From: Amber Willard <Amber.Willard@arun.gov.uk>
Sent: 11 August 2020 11:31
To: Planning.Responses <Planning.Responses@arun.gov.uk>
Subject: FW: Planning application AW/161/20/HH

From: Ron Hurstwaite [REDACTED]
Sent: 11 August 2020 10:10
To: Amber Willard <Amber.Willard@arun.gov.uk>
Subject: Planning application AW/161/20/HH

I wish to object to the above application for the following reasons.

Site Plan

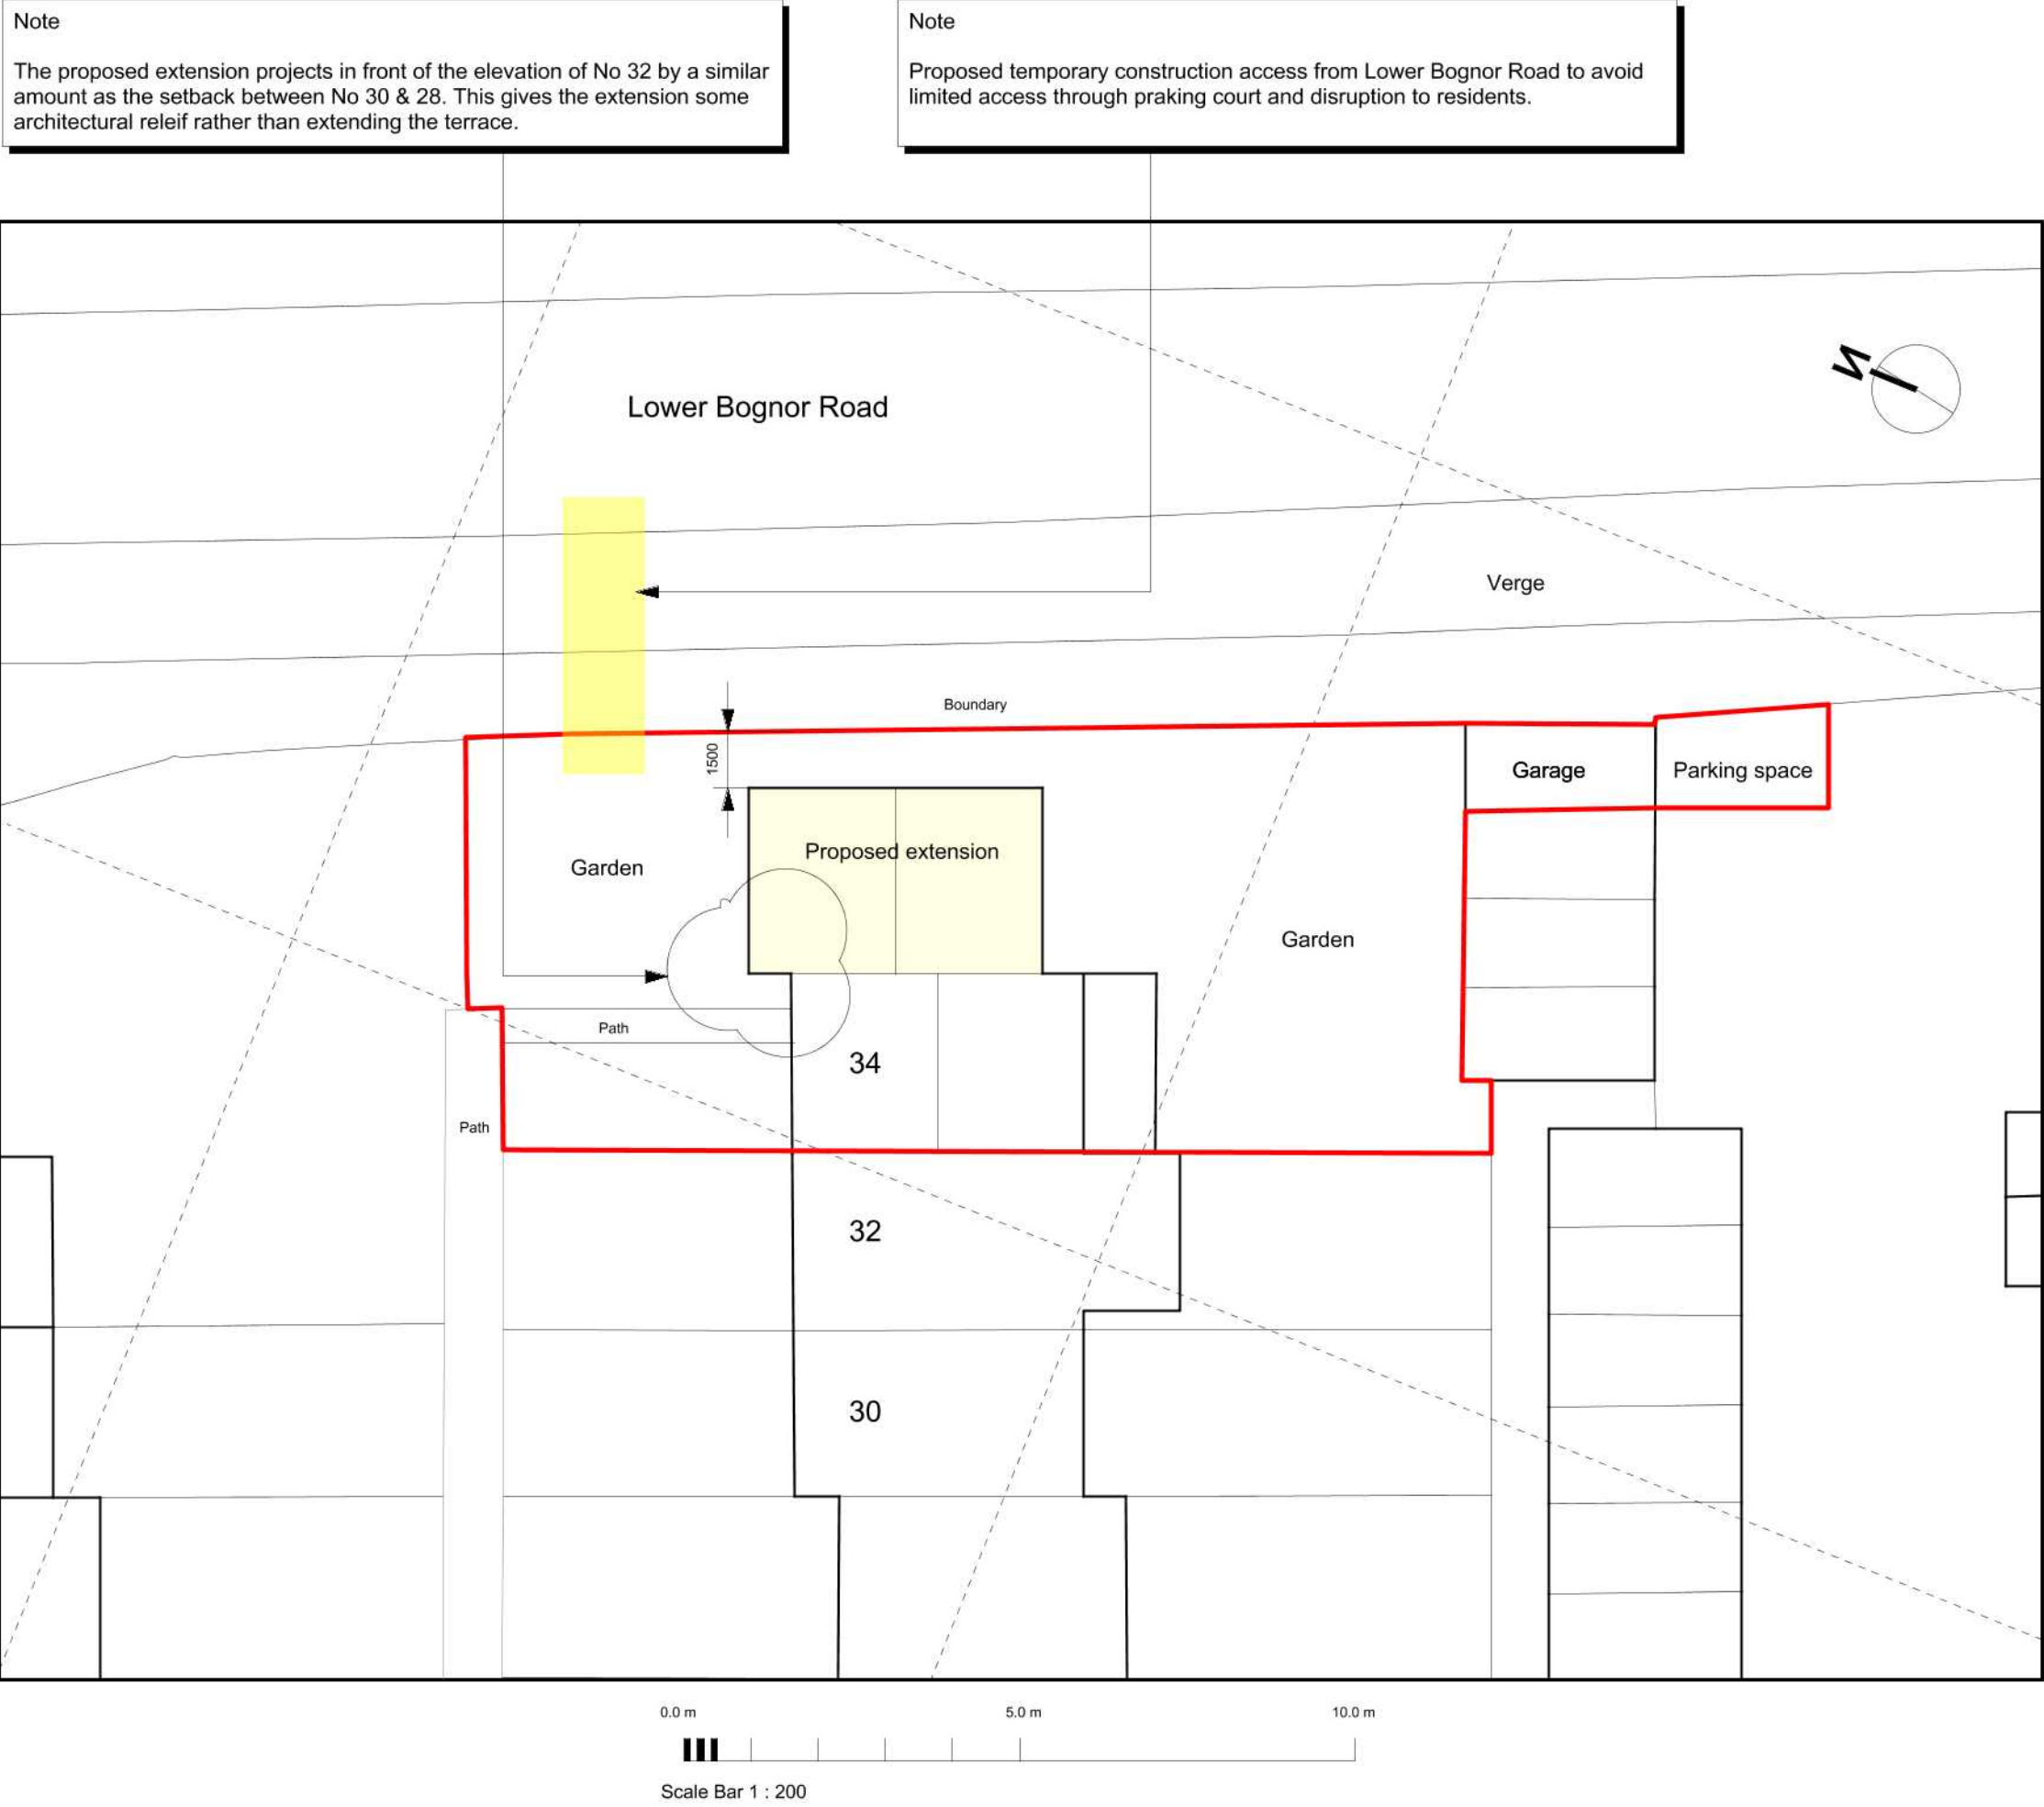
The allocated parking space proposed is in a communal area used by myself and other residents as a turning point when leaving our garages. It will make it very difficult to navigate with a parked vehicle there. This land is not owned

by No 34 but as stated is communal for all to use. Parking remains a major issue with a lack of spaces for the current properties.
